Summary comments.

The solar park is located within North Kesteven District and the eastern boundary of the site runs along the Borough / District boundary. The Borough has residents that are about 800m from the site boundary. One dwelling that fronts the A17 will be about 450m from the solar park and will have the cable route pass to its north and east. The impact of the solar park on Boston Borough residents is reduced by distance, any intervening natural and built landscape features and the proposed boundary hedge to the solar park.

We have undertaken a high-level review of the submitted documents focussing on topics that directly or indirectly impact the Borough's residents. We make the following Relevant Representation, which can be summarised as follows:

FIGURE 4.1e PROPOSED ECOLOGICAL ENHANCEMENTS FOR OPERATIONAL ENERGY PARK

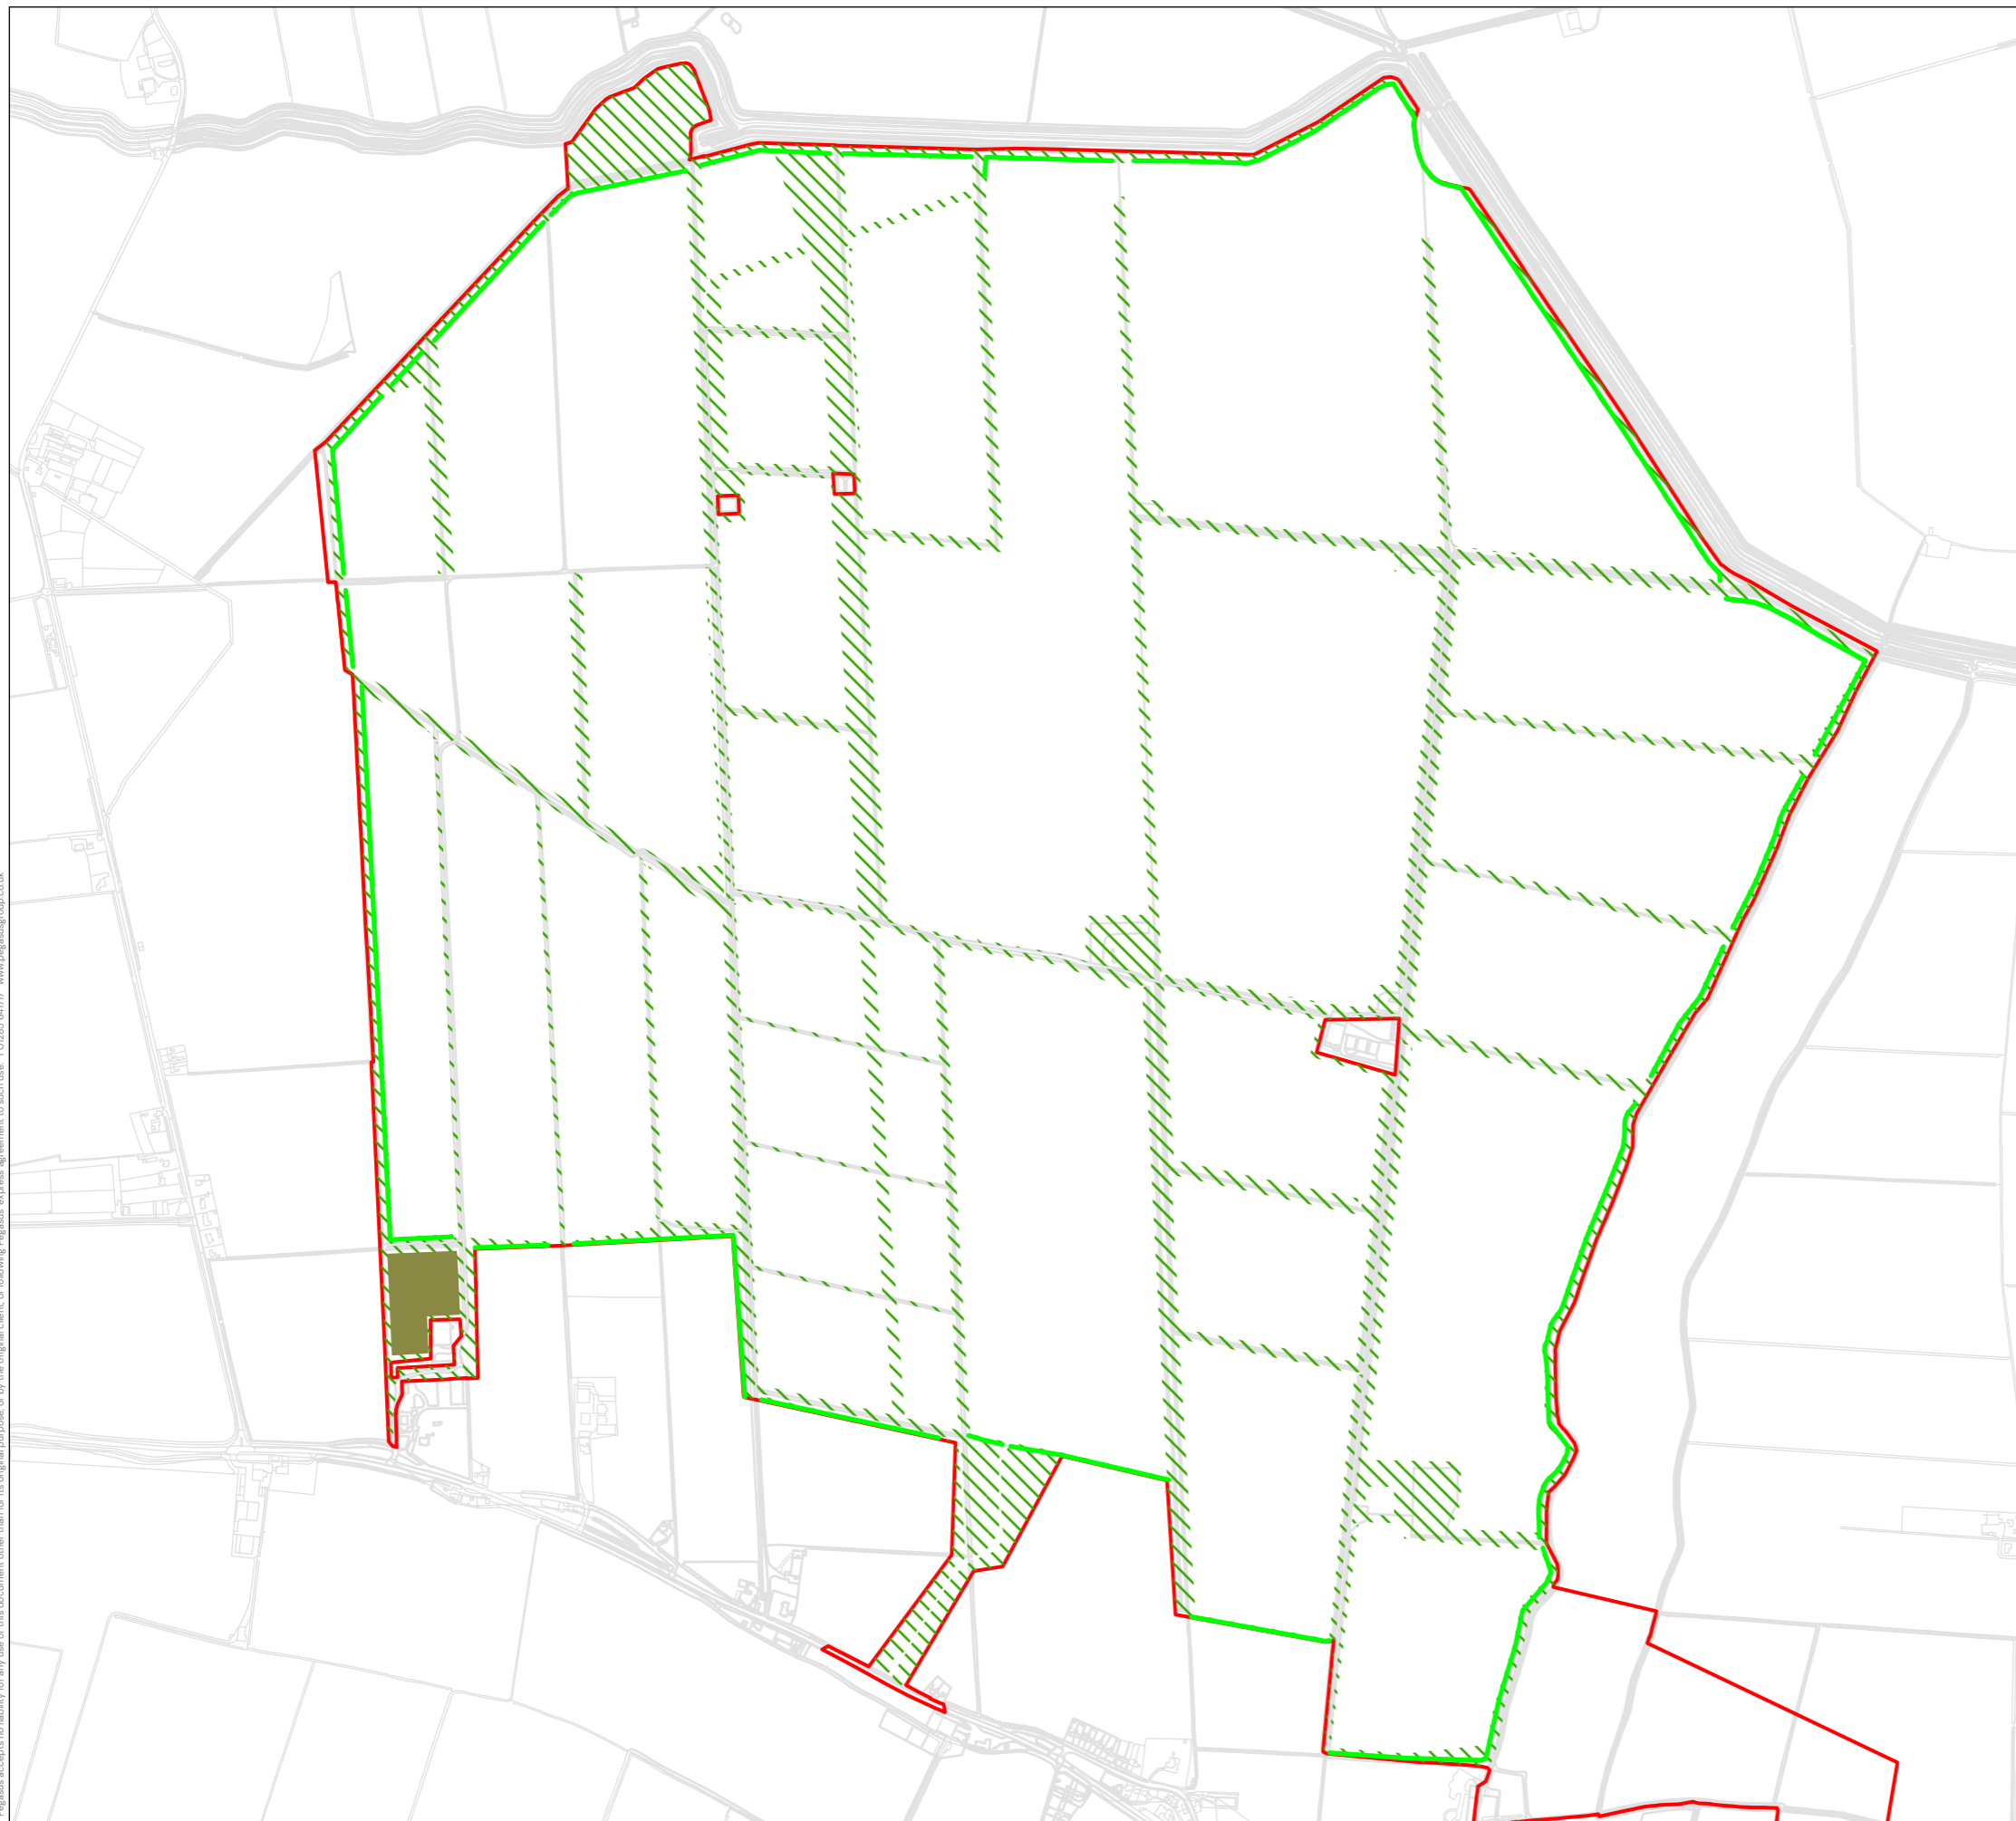
- Various documents consider landscape and residential visual amenity, noise and vibration plus glint and glare. Outlook from the properties and the consequent impact on residential amenity is mitigated by the expansive nature of the location, distance between the Solar Park and the dwelling and any intervening landscape features. Two viewpoints in the Borough will experience a significant effect for a temporary period as the cable is installed. None of the properties judged to be visually affected are in the Borough but mitigation measures for the dwellings in North Kesteven will also benefit dwellings in Boston Borough such as physical separation, reducing the height of the panels and the position of the sub station. Glint and glare on residents of the Borough relates to Boston Aerodrome, users of the A1121, part of the A17 and living near to the solar park. The highways have the potential for Significant effect prior to mitigation. This becomes Not Significant after mitigation. For residential impact there are a number of observation points that have been used to assess impact. Those in Boston Borough are OP24 to OP34. The impact on OP24 to OP28 are Not Significant. The impact on OP29 to OP34 is Significant prior to mitigation and Not Significant after mitigation. A mitigation feature is the planting of a boundary hedge but the height is different in different documents. The height needs clarifying.
